**From:** Marlow, Angela (NE) [REDACTED]  
**Sent:** 23 August 2016 10:56  
**To:** Simon Davis  
**Cc:** Roger Spencer  
**Subject:** re:P/97/15/PL - Pagham Harbour managed breach

**From:** Marlow, Angela (NE) [REDACTED]  
**Sent:** 23 August 2016 13:46  
**To:** Simon Davis  
**Cc:** Roger Spencer  
**Subject:** FW: Pagham - Conditions associated with unblocking the harbour mouth

Proposed planning conditions Pagham Harbour breach.

Figure 1

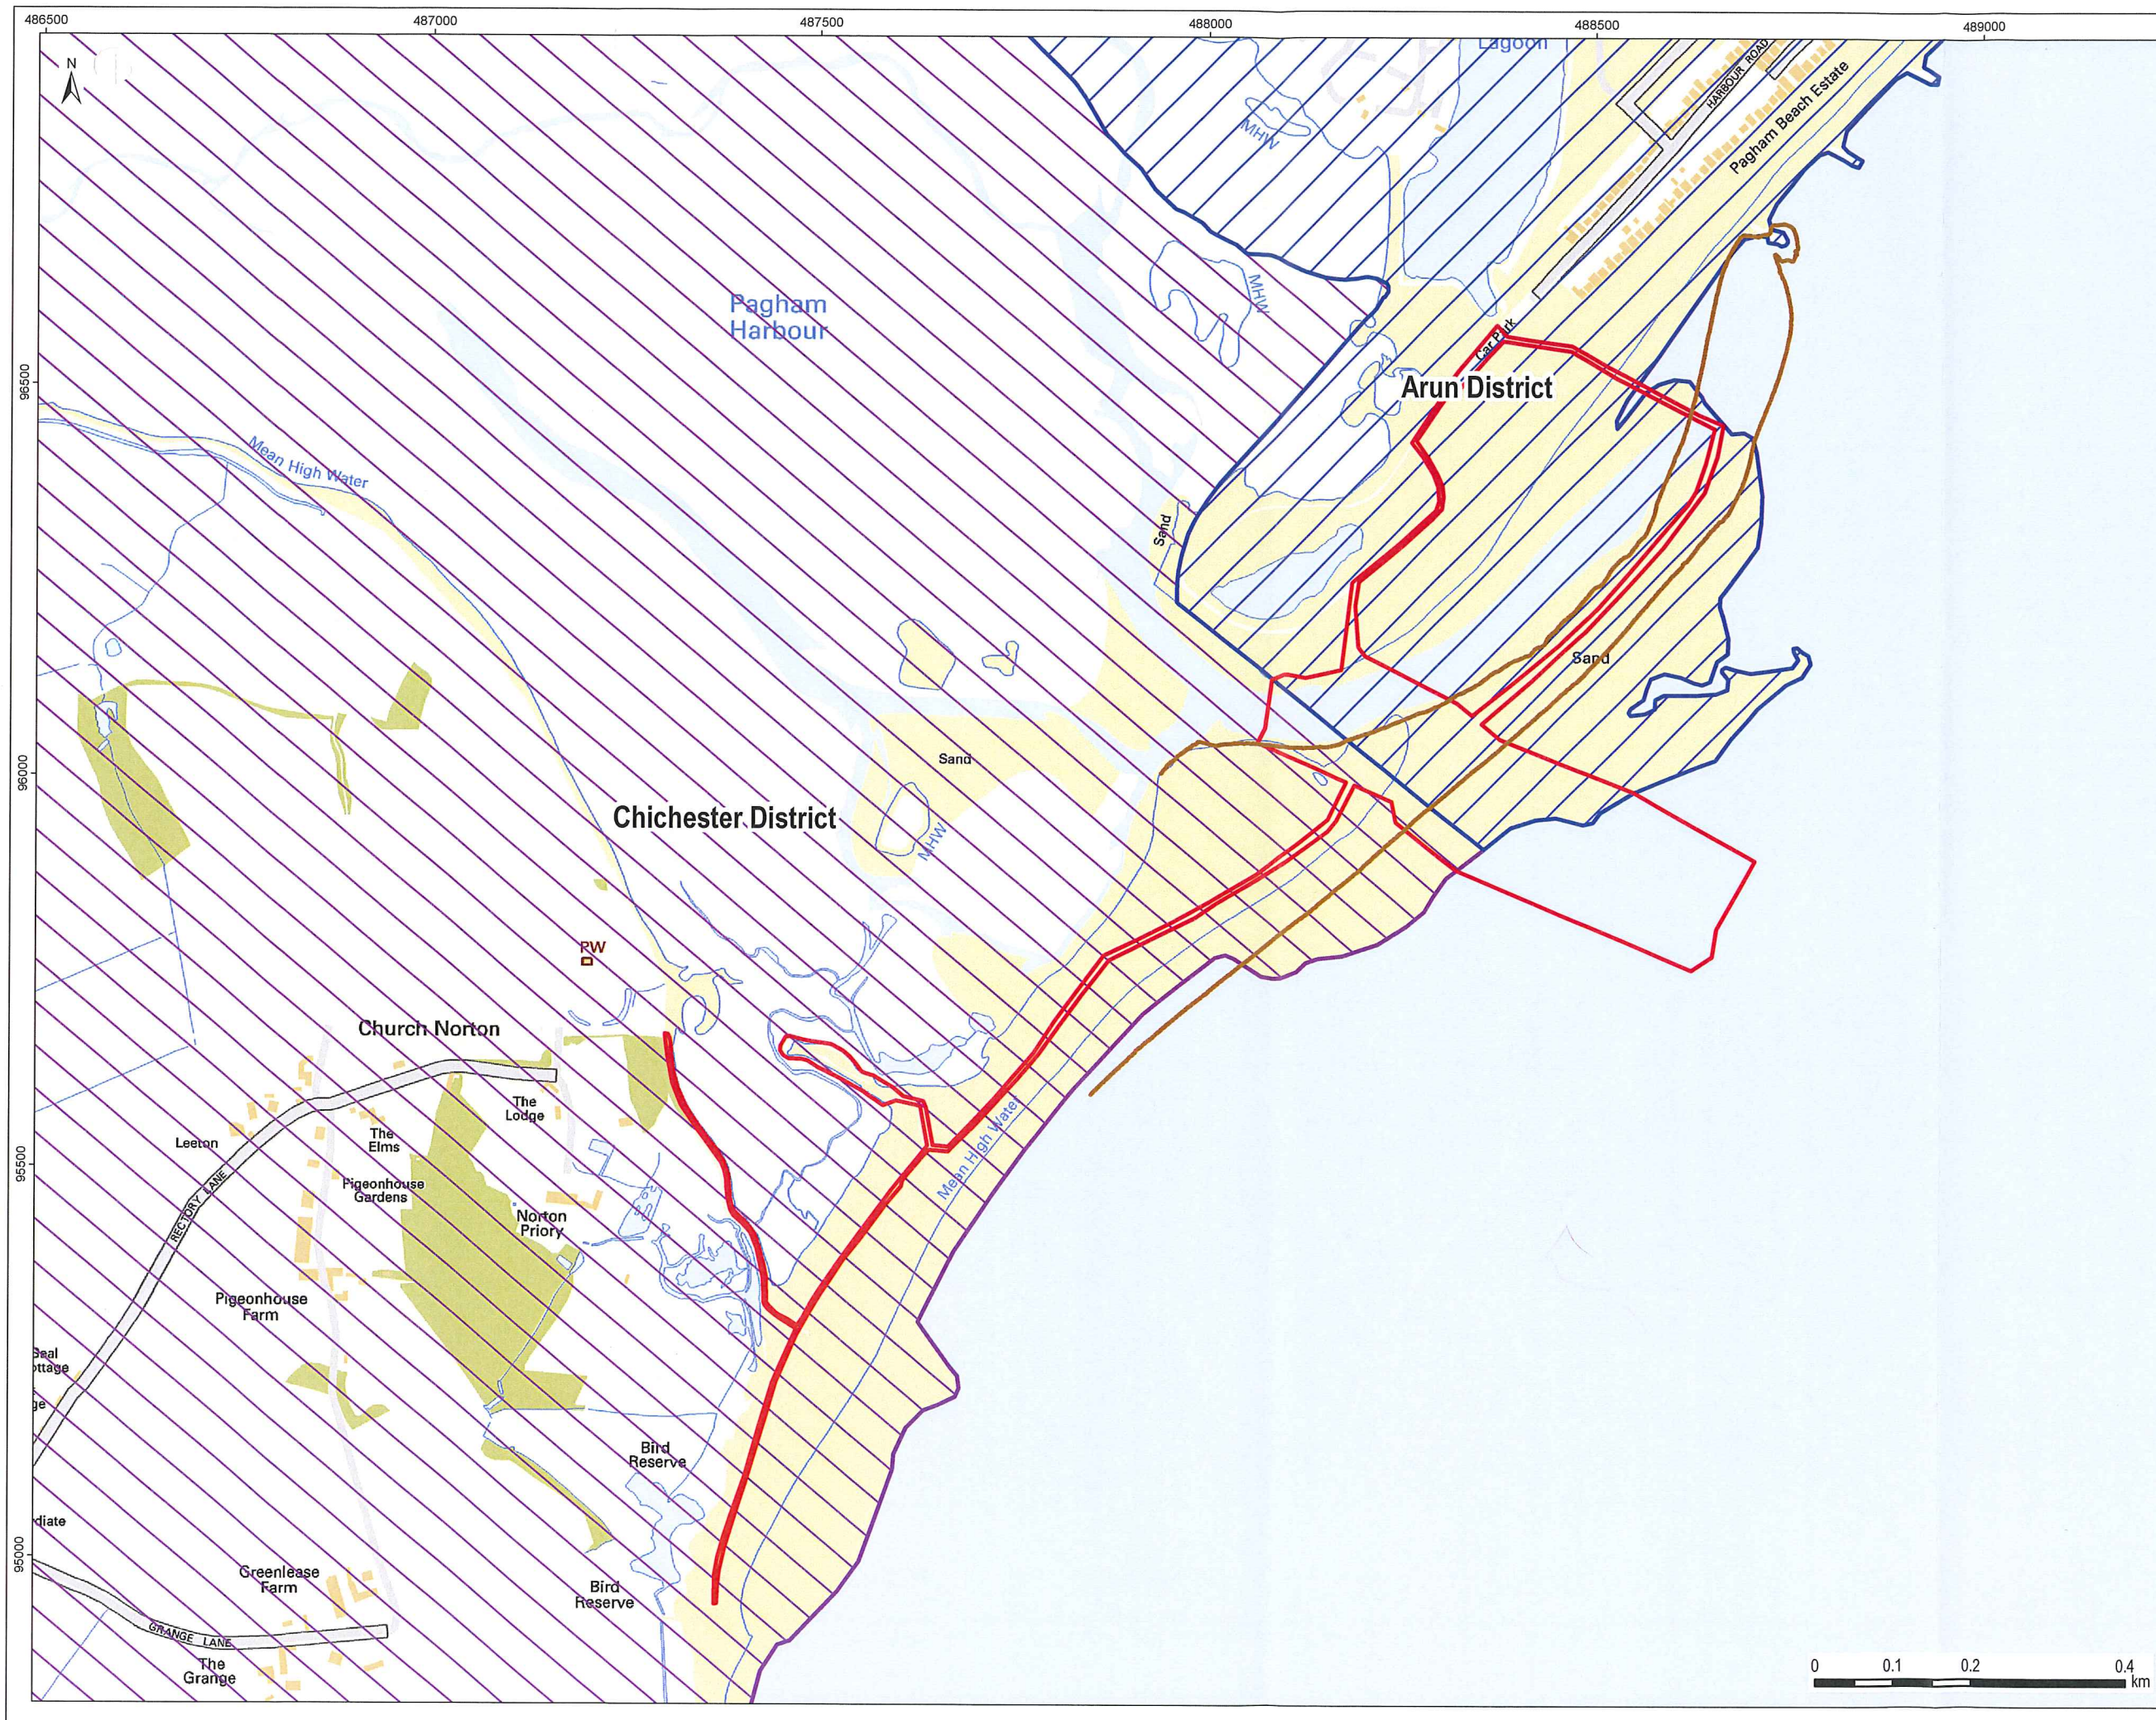
iii. The lowering of the inner part of the wide existing crest of the 'historic' spit located updrift of the breach could also be considered (see figure 1). Presently, the crest here is artificially elevated as a result of historic engineering works, and will prevent the natural evolution of the spit via periodic overwashing of gravel. Lowering the crest to a more natural level would avoid this issue.
